Consultation Response from KC Conservation and Design
2018/92687 former Kirklees College, New North Road, Huddersfield, HD1 5NN
Listed Building Consent for alterations, demolition of part the grade ii* listed building and other curtilage listed buildings (within a Conservation Area)
Date Responded: 9.10.20 Responding Officer: Sue Oakley Responding Ref:

Client:	Trinity One LLP	Job No:	16,047
Project:	Former Kirkstalls College Site - Building 5		
Title:	Levels 01-03 GA Plan		
Date:	24/07/20	Scale:	As indicated BA1
Drawing No:	20-511	Checked by:	RG
		Drawn By:	MP
		Revision:

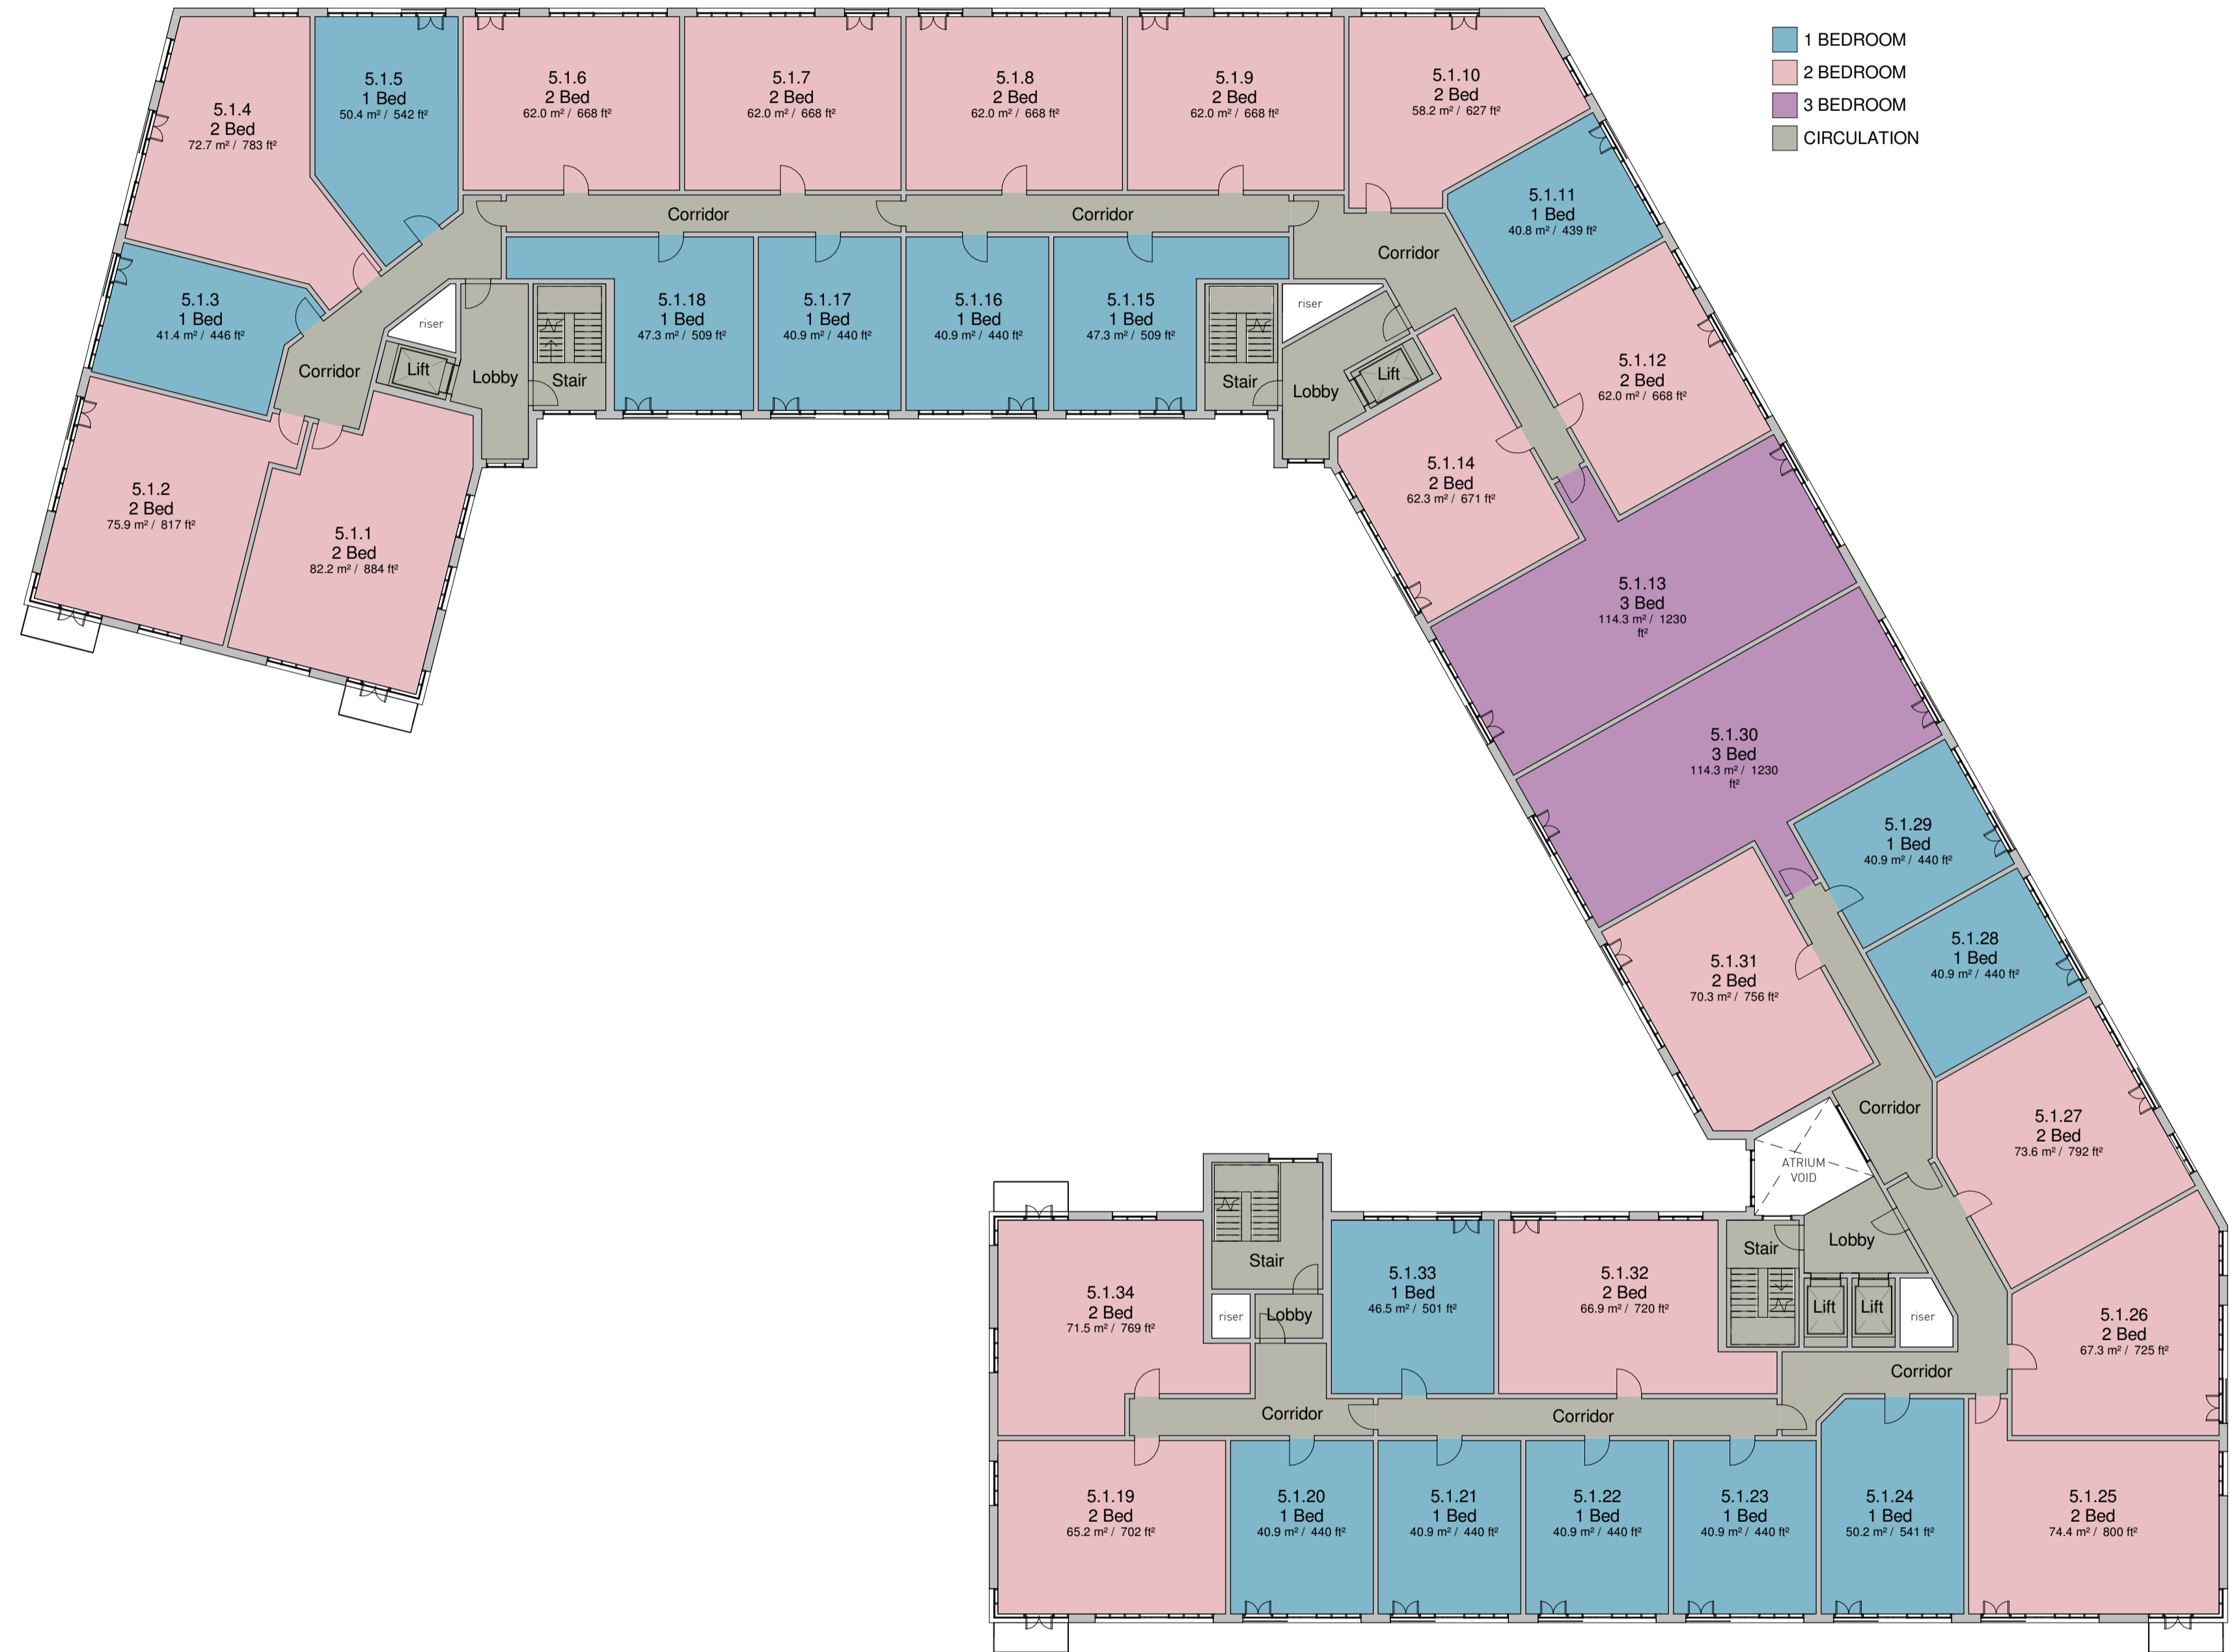
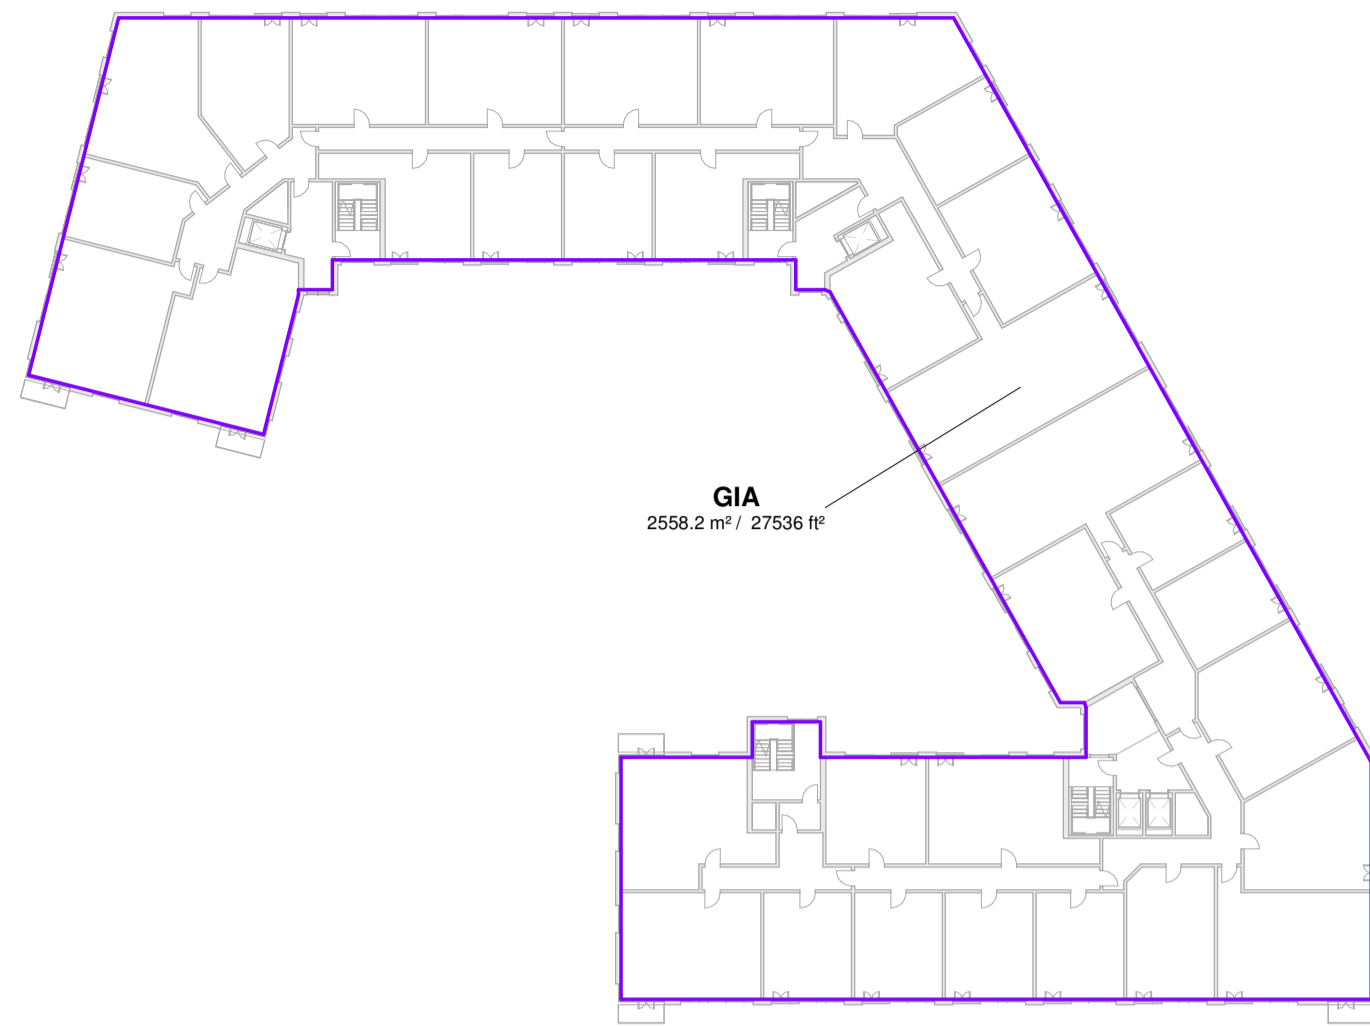
I am concerned about the design, scale and positioning of building 5 and its dominance over the two-storey listed infirmary building on the site as well as the listed church and properties on New North Road, which would sit directly opposite this new structure. Historic maps from the late 19th and early 20th centuries indicate that there were terraced houses close to the boundary of the site at the northern end and the design and access statement has used this urban grain to inform the proposed footprint.

The heritage assessment states that the proposed height of buildings 4 and 5 reflects that of the existing buildings on the northern part of the site, also reflecting the historic development that occurred prior to the construction of Building G (the terraced houses). However, the existing multi-storey buildings are set back from the north and east boundaries and I would consider building 5 to have significantly more impact on the infirmary and surrounding listed buildings than the existing structures due to its location directly on the site boundary.

Given the fairly standard design of Buildings 4 and 5 and their dominance over the surrounding listed buildings, I would like to see amendments to their design, with more consideration given to the immediate context and with the retention of elements of Building G. I consider that in their current form these elevations harm the setting of the listed buildings, in particular the infirmary and St Patrick's Church, and while I understand that the site is in need of improvement, they should be redesigned to complement their setting.

To the north of the site are three Grade II listed former dwellings, 112 to 116 Fitzwilliam Street, along with the listed boundary wall of number 112. I consider the impact of Building 5 on the setting of these listed buildings to be less, although the scale and design should also be considered carefully in this prominent location.
